Re: Proposed Residential Apartment Building: 424 Churchill Avenue North

Addendum #1 to Traffic Impact Assessment Final TIA Report originally dated June 8,

2023 (Castleglenn Project 7303)

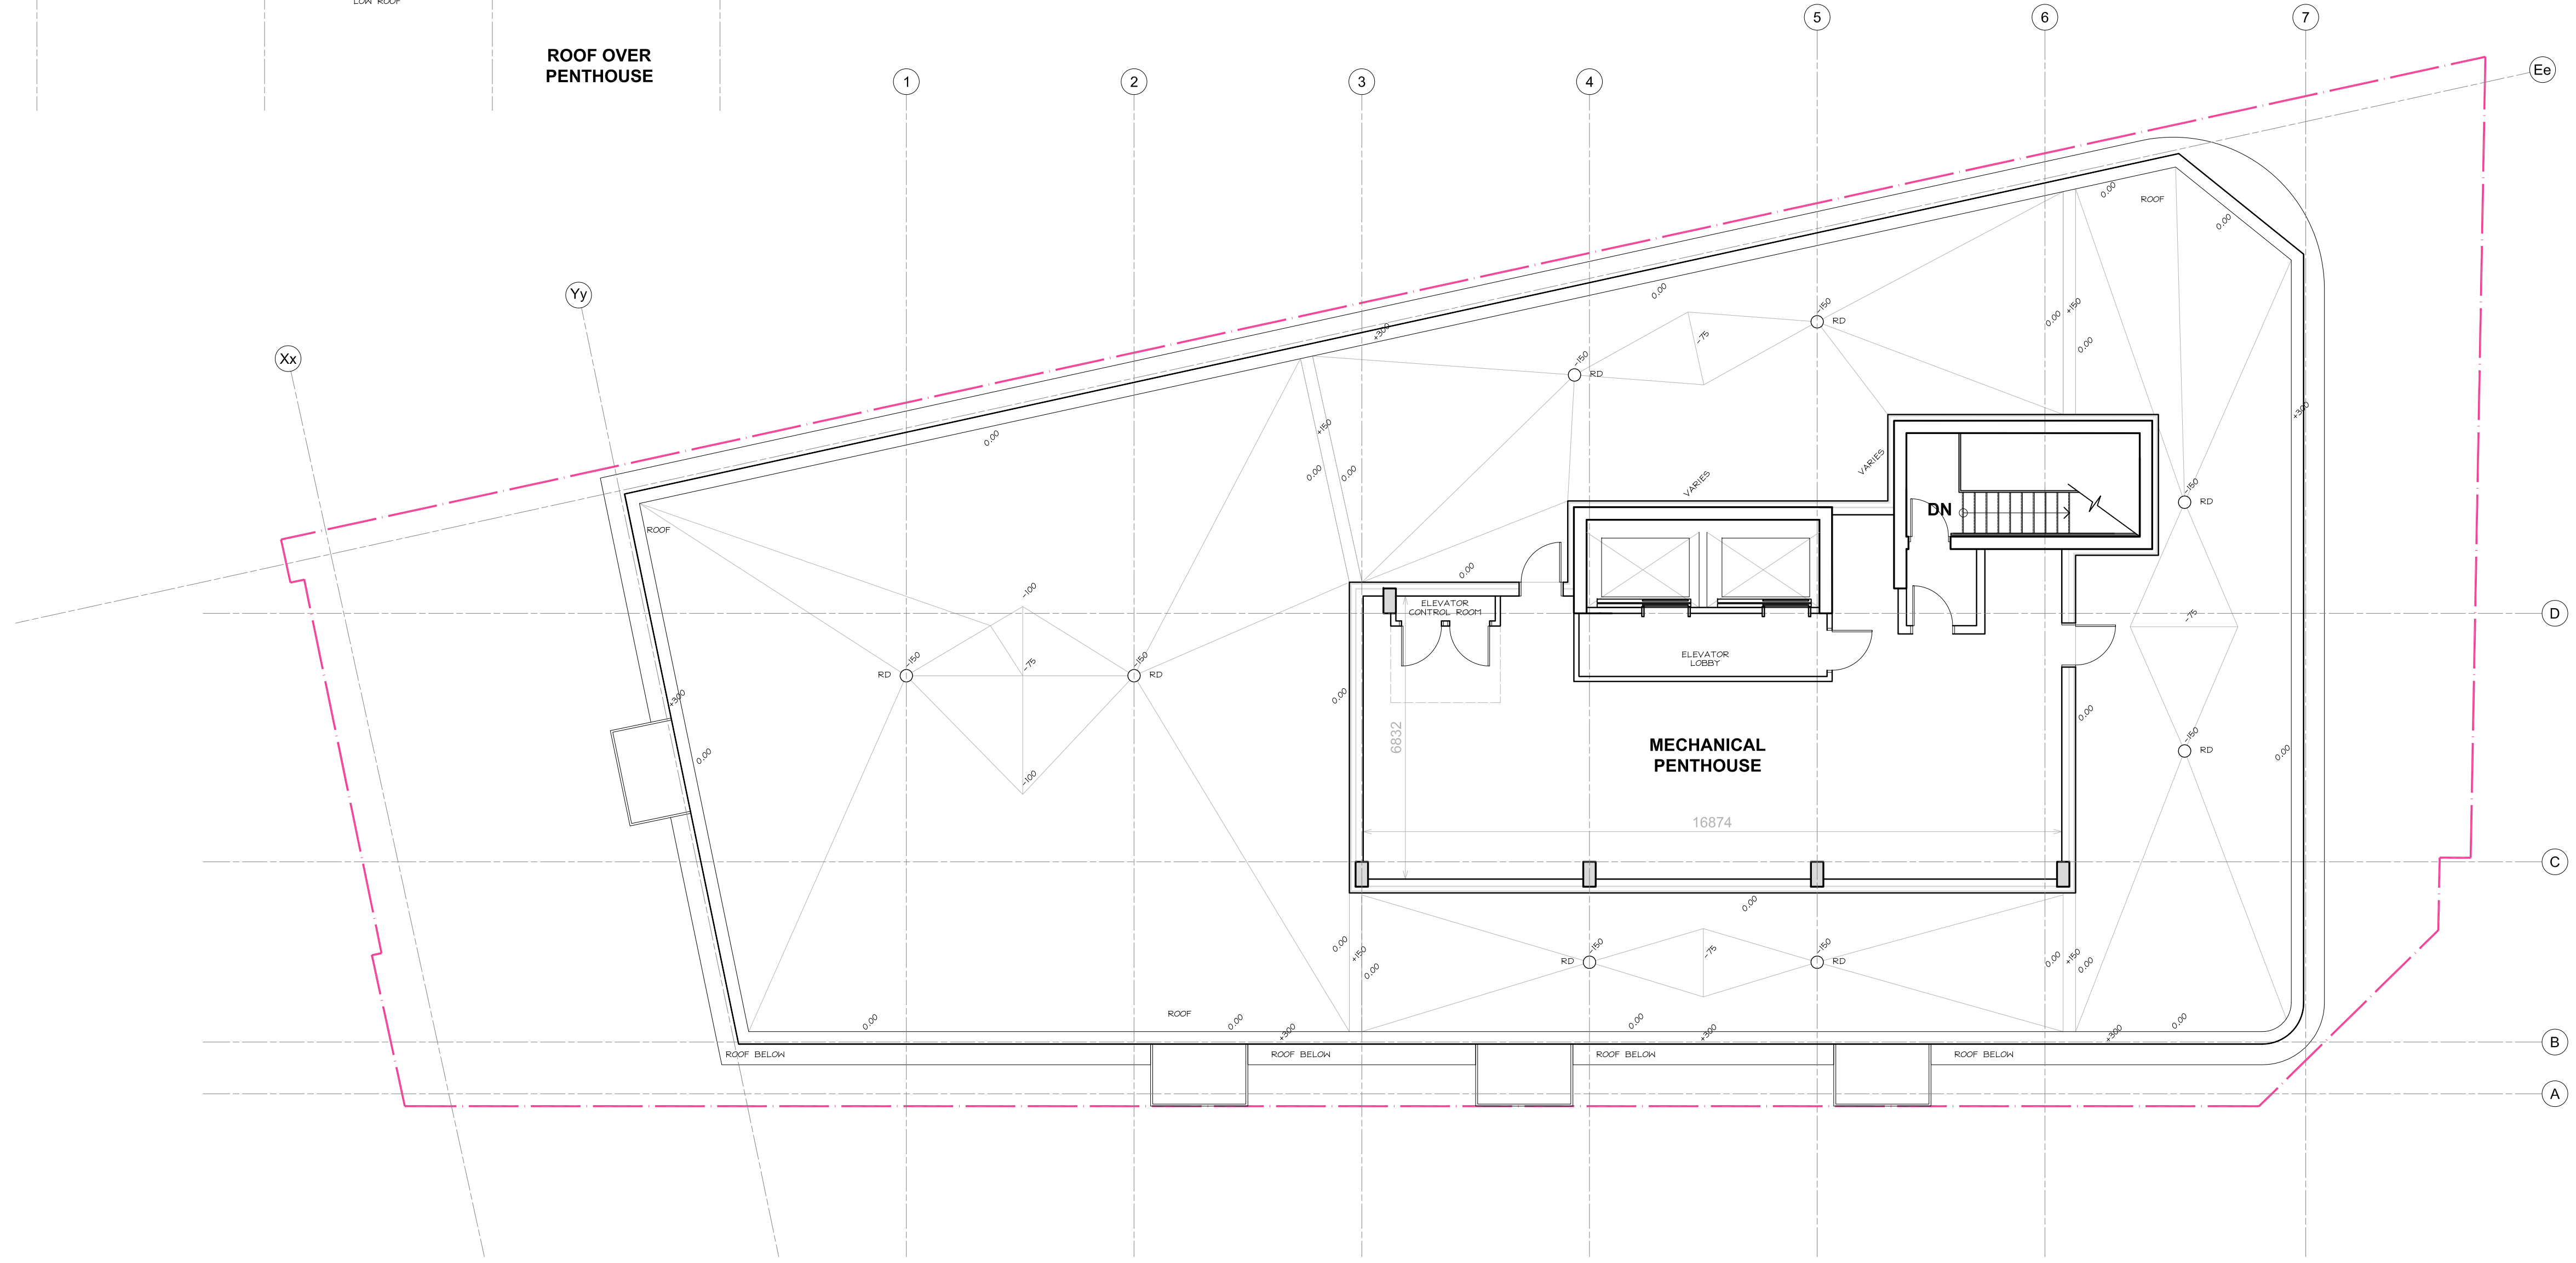
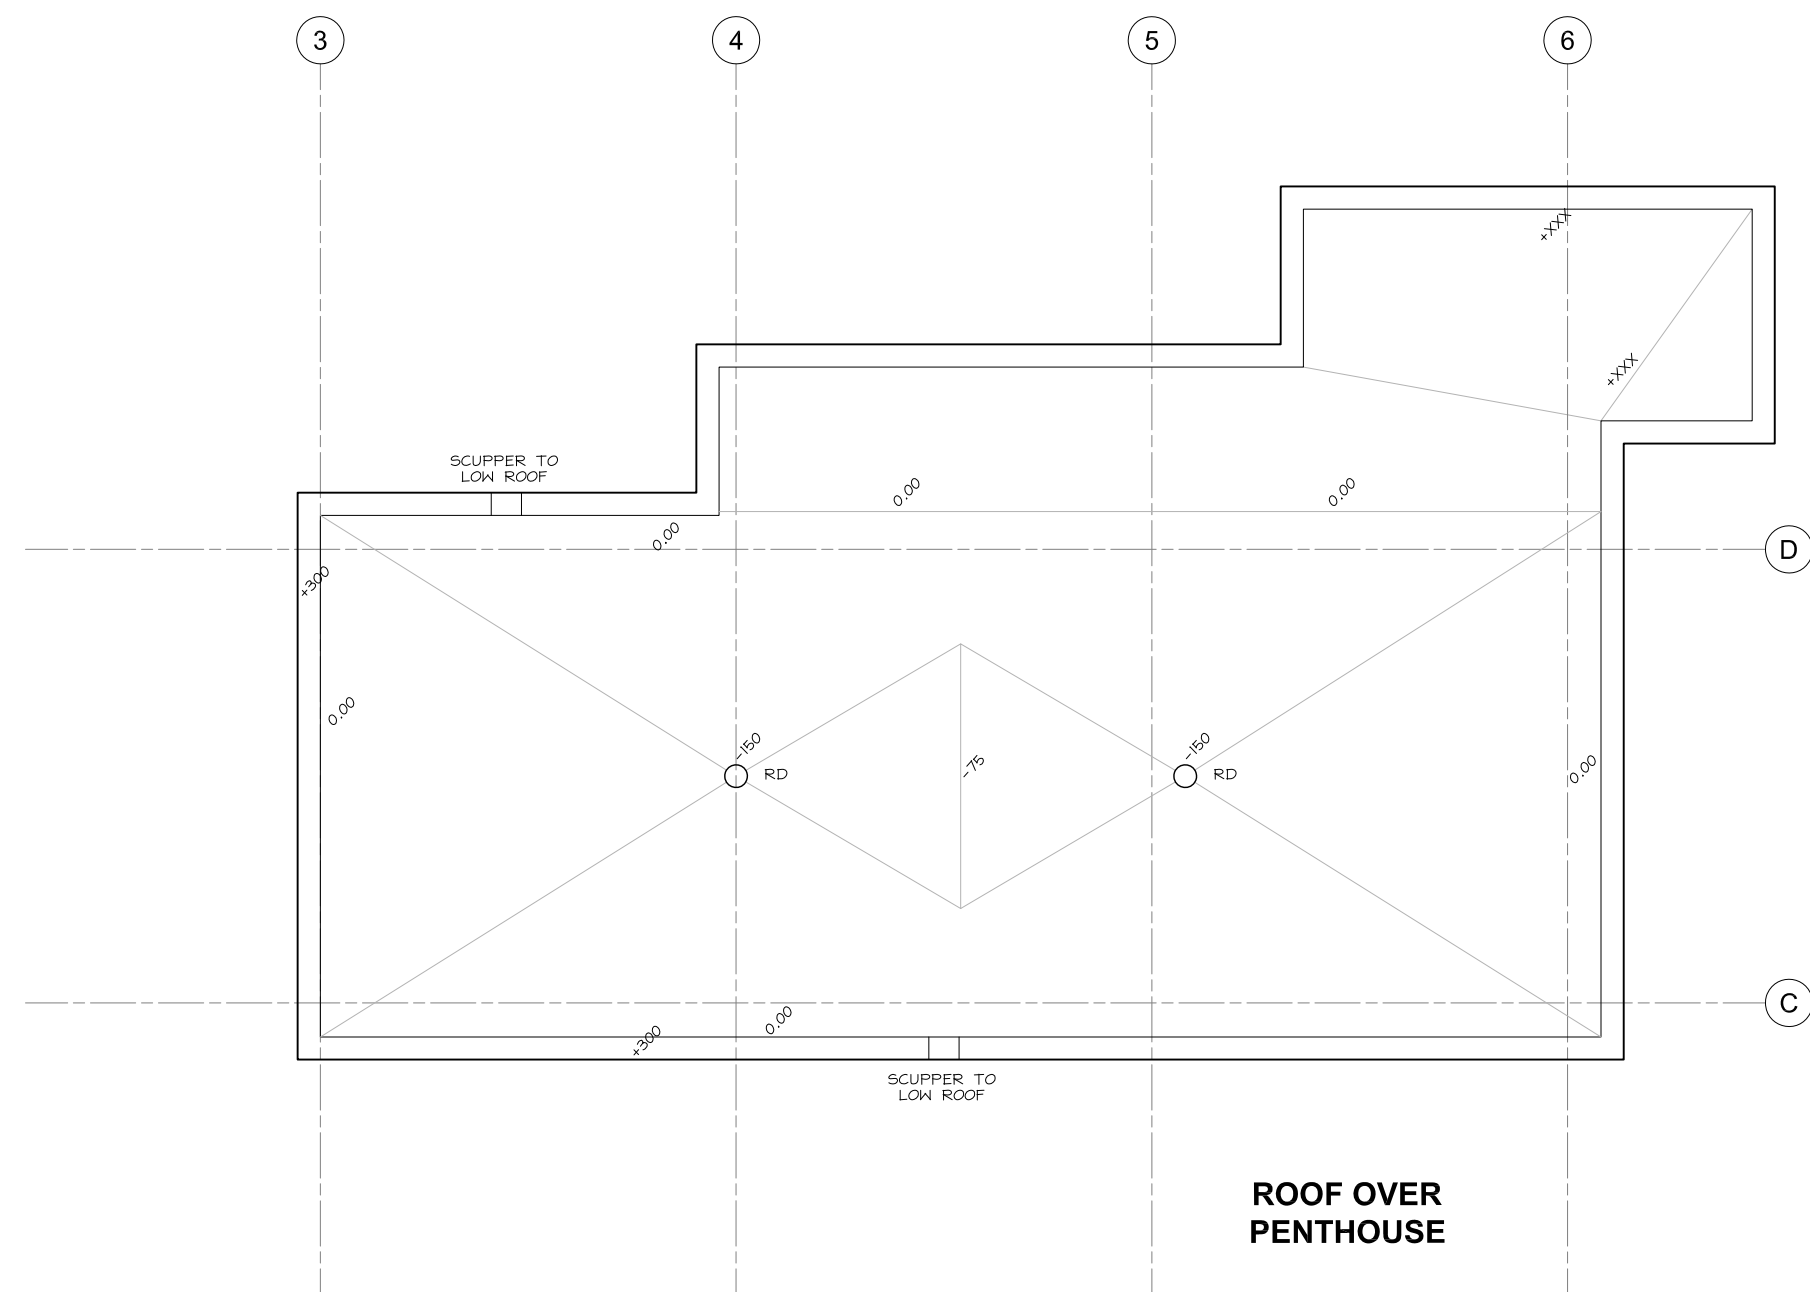
The parking supply referenced in the section 6.2.1 of the originally submitted report stated that 33 motor vehicle parking stalls are provided by the development. The constraints introduced by removing a 5x5 corner triangle from the building's underground parking levels resulted in a loss of two parking stalls in the easternmost corner of the parcel.

An updated Table 6-1 below provides an updated parking provision summary per new site plan, which totals to 31 stalls, representing a decrease of 2 residents' parking stalls – one stall on each parking level. The updated parking provisions (31 stalls) continue to meet the City of Ottawa's Zoning By-law requirement (28 stalls).
